Your Ref: OWPC23746
Our Ref: K/19/19/HH 25-06-2019
Please ask for:
Zac Denton

Two storey rear extension with a small canopy projecting the footprint to the front.
Demolition of existing living room and additional first floor for habitable use with alterations to fenestration.

Little Tangle Middle Way Kingston Gorse East Preston

Thank you for your internet representation made on 23rd July 2019 which has been recorded as '**an objection**' with the comments as follows:

EXISTING  
ELEVATIONS

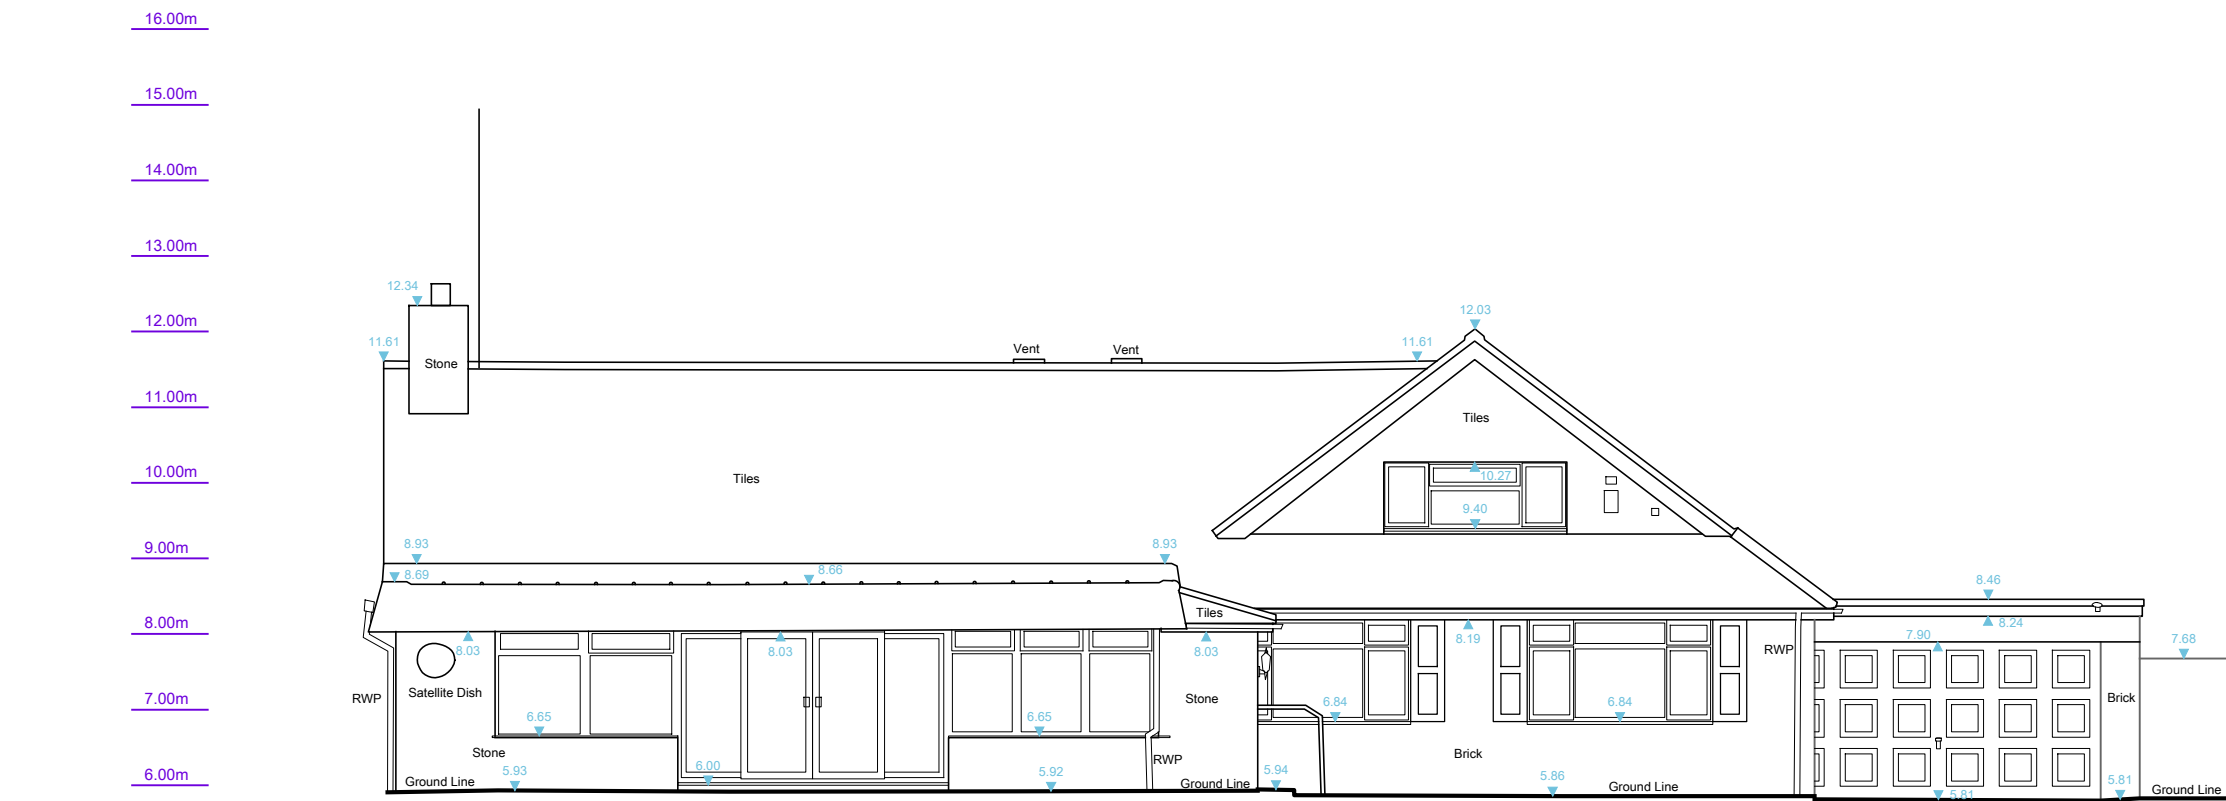
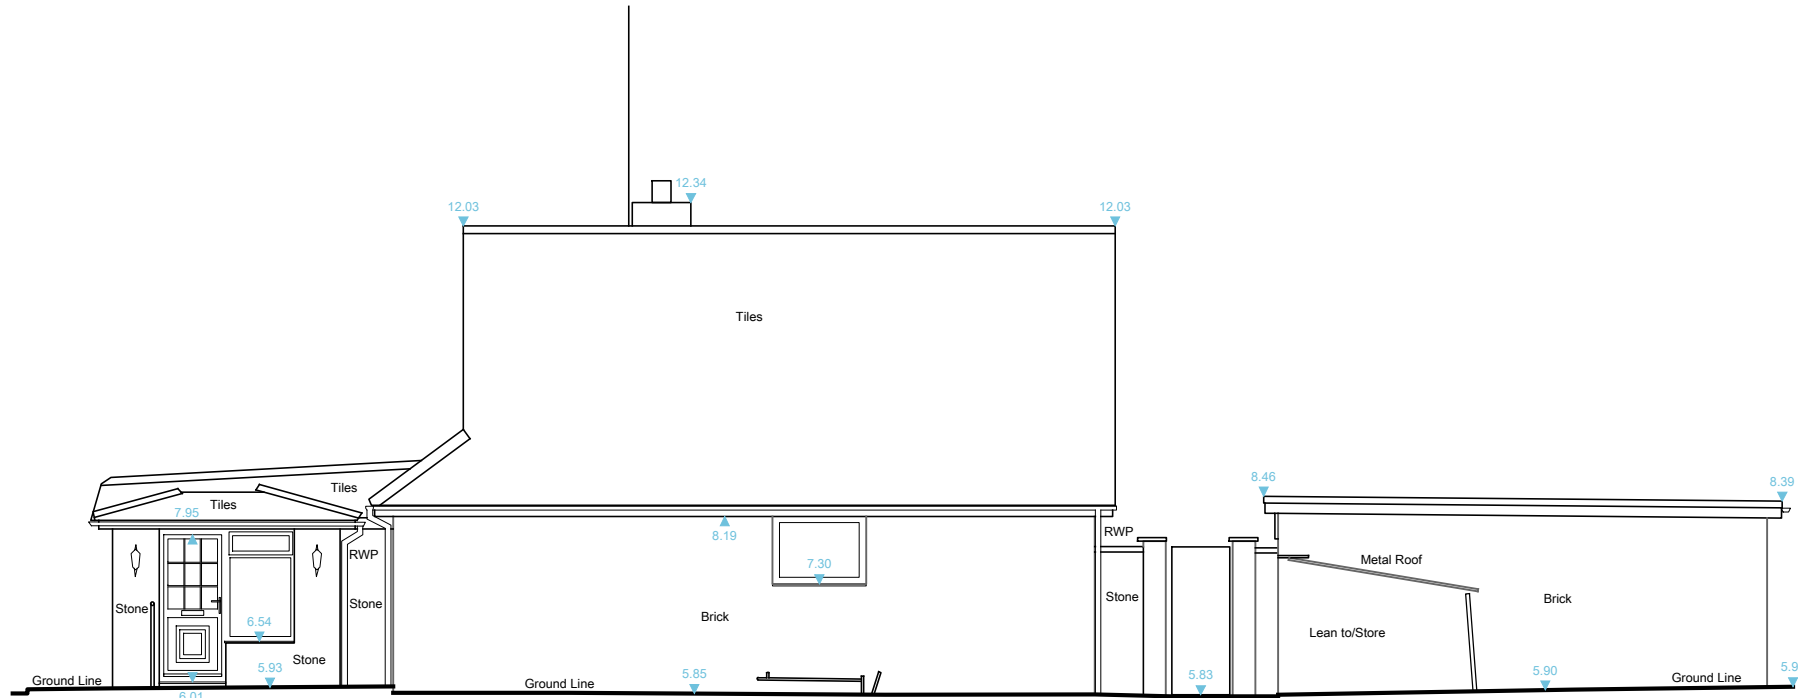
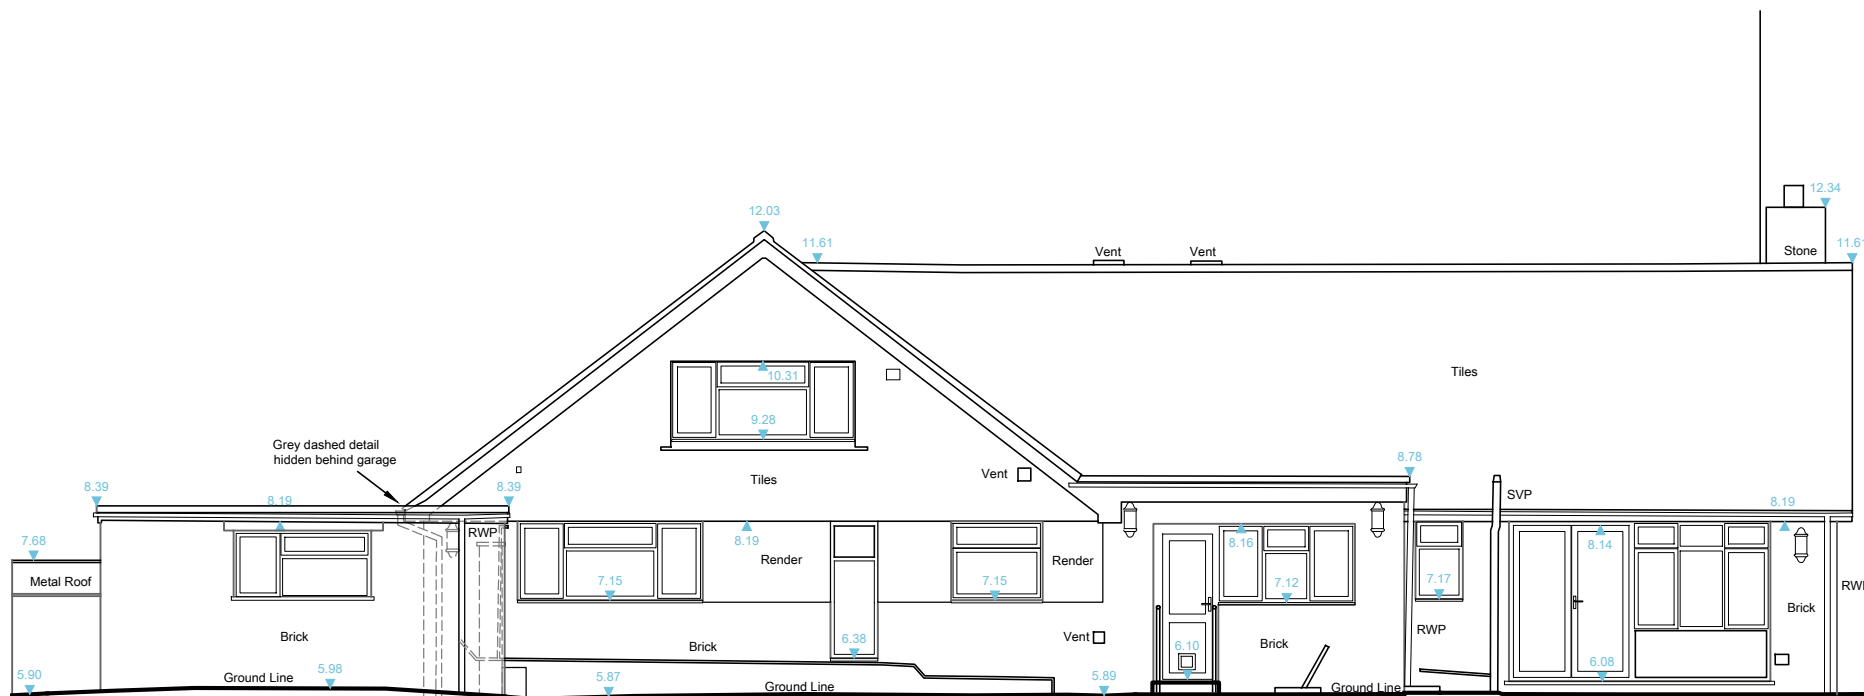
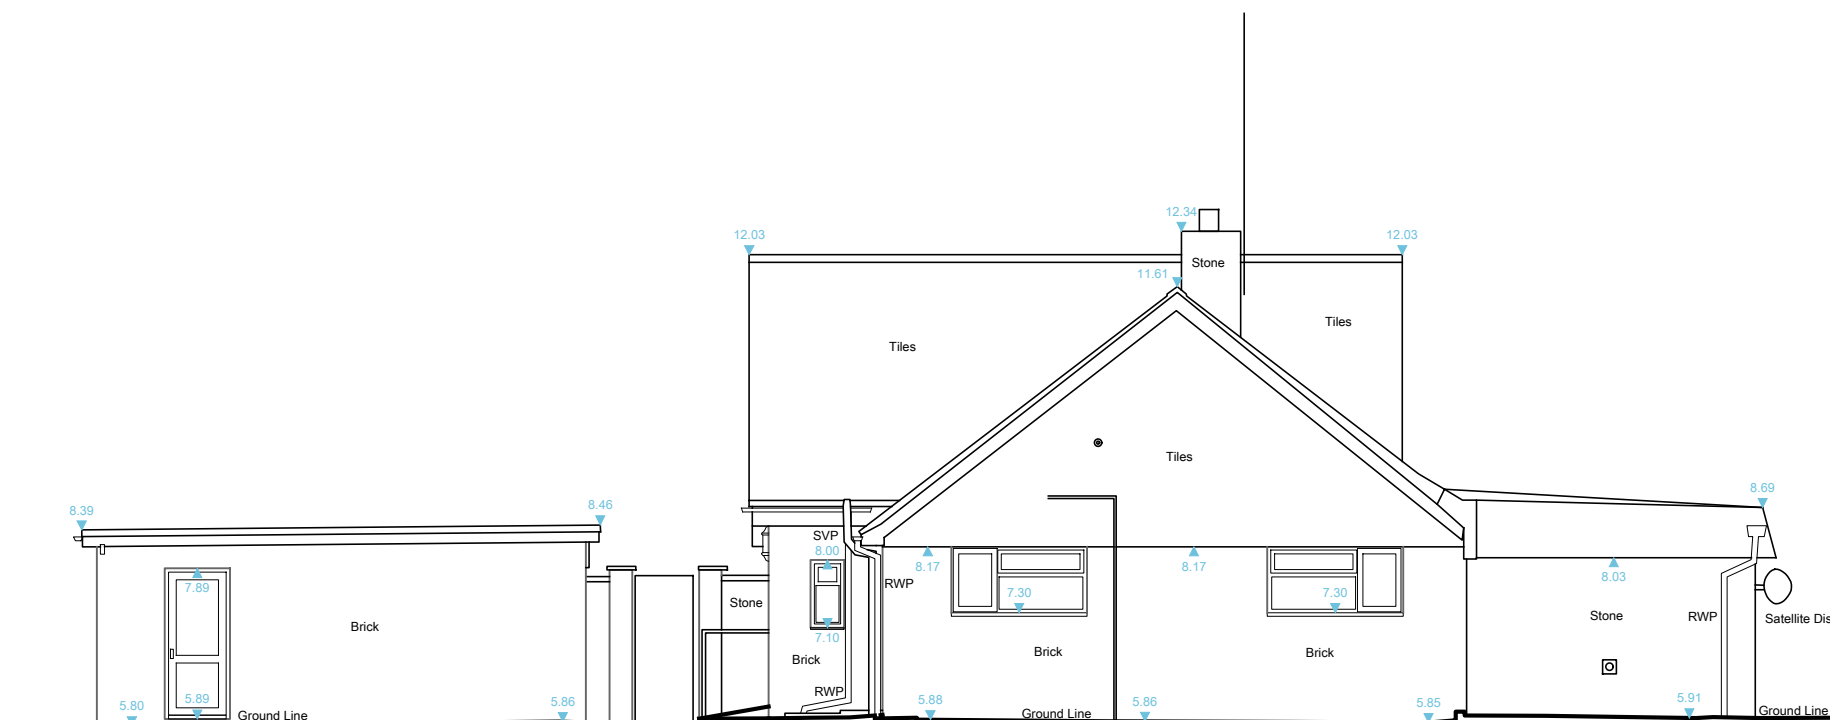
4. There is to be a window on the ground floor east elevation. One exists today but it is small, opaque and virtually invisible due to the height of the side fencing. It is unclear from the drawings if this is to be maintained or changed in anyway i.e. size, glass type etc. We are assuming any planning approval would require the current level of privacy to be maintained.
